PLANNING APPLICATION: Register Reference No. **25/60320**

Location of Development: Ragoon, Knocknacarra, Galway

Re: Appeal to An Coimisiun Pleanála Third Party Appeal against decision to Grant Permission.

Proposed Development: Notice for a Large-Scale Residential Development Application to Galway City Council. Permission for development which consists of: We, Kingston Stables Limited, intend to apply for permission for development of a Large-Scale Residential Development (LRD) for a 10-year planning permission, on a site which extends to 5.37 ha on lands located at Ragoon, Knocknacarra, Galway. The application is being made under the provisions of the Planning and Development (Amendment) (Large Scale Residential Development) Act 2021. The proposed development will consist of: 1. Provision of 362 no. residential units in 4 no. development areas with a mix of apartment and house types on a site area of 5.37 ha. The buildings range between 2 no. and 6 no. storeys in height. The development will comprise the following: • 4 no. 2-bed townhouses; • 40 no. 3-bed townhouses; • 21 no. 4-bed townhouses; • 15 no. 1-bedroom duplex apartments; • 46 no. 2-bedroom duplex apartments; • 15 no. 2

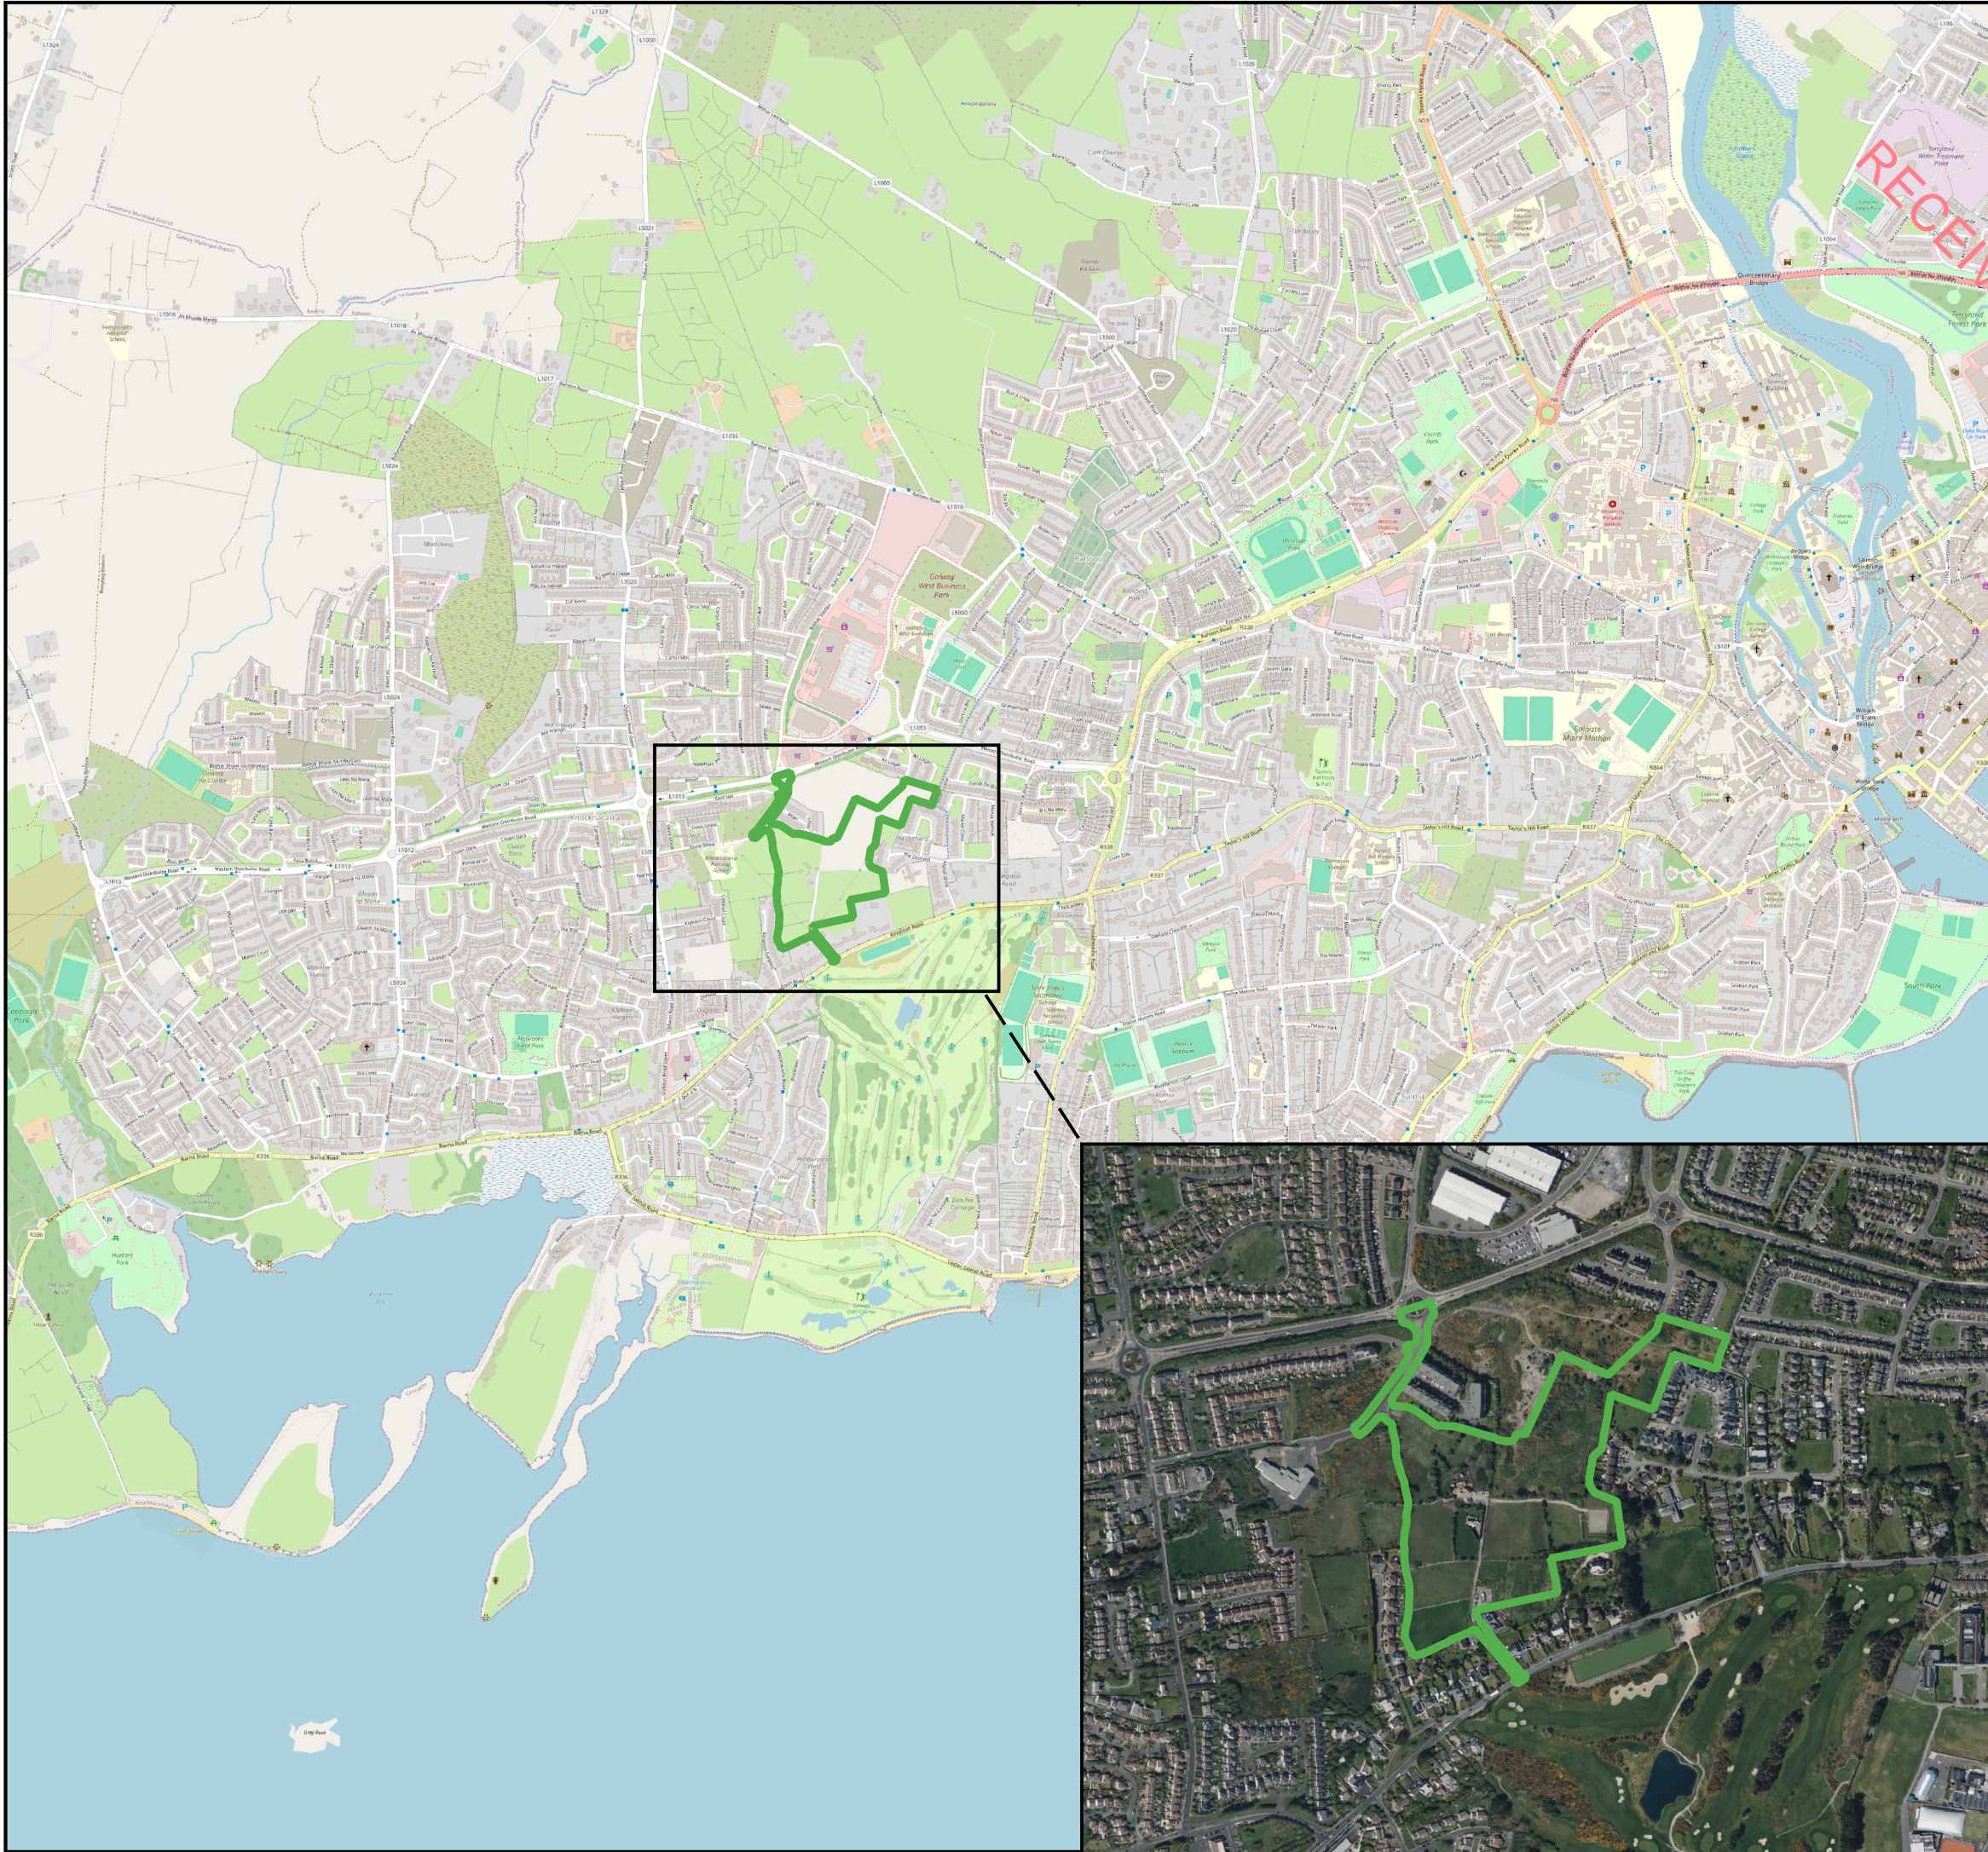
I have already noted that in the Bat Study that it states that my house is the centre of the EIAR study. Figure 1-1 of the EIAR as mentioned above shows my house included in the EIAR (it is not excluded as shown on the site location map for this Planning Application). There are numerous maps and aerial photographs shown in both the EIAR and the NIS which show my house and site as being part of the EIAR study area and the above paragraph. Paragraph 2.2.4 of the EIAR is self-explanatory with regards to future Development and the MASTERPLAN and it is followed by Figure 2.3. Figure 2.3 clearly shows a future development for the area with my house and site have been demolished/vanished and a green area and some houses on it. My house and site are clearly shown as part of the Masterplan in this figure 2.3. Galway City Council in the Planners Report clearly shows in at least 13 areas that the fact that there is a masterplan for a larger site that it is on this basis that they decided to grant Planning Permission in my opinion.

Any 'Reasonable Person' as defined by the Courts by looking at figure 2.3 of the EIAR would assume that my house and site are part of the Masterplan and Proposed Project as mentioned in both the EIAR and the NIS that accompanied this application in my opinion.

I can state that my house and site are not part of the Masterplan and proposed project and should not have been shown in this figure 2.3 or any other drawings and aerial photographs in the EIAR and the NIS. Therefore, in my opinion, I think that it is only reasonable that the EIAR and NIS are withdrawn from this Planning Application in my opinion as they show an area being my site as part of a Masterplan and there is no permission to do so. An Coimisiun Pleanála should take no regards of these documents in making your decision on the Application in light of these matters in my opinion.
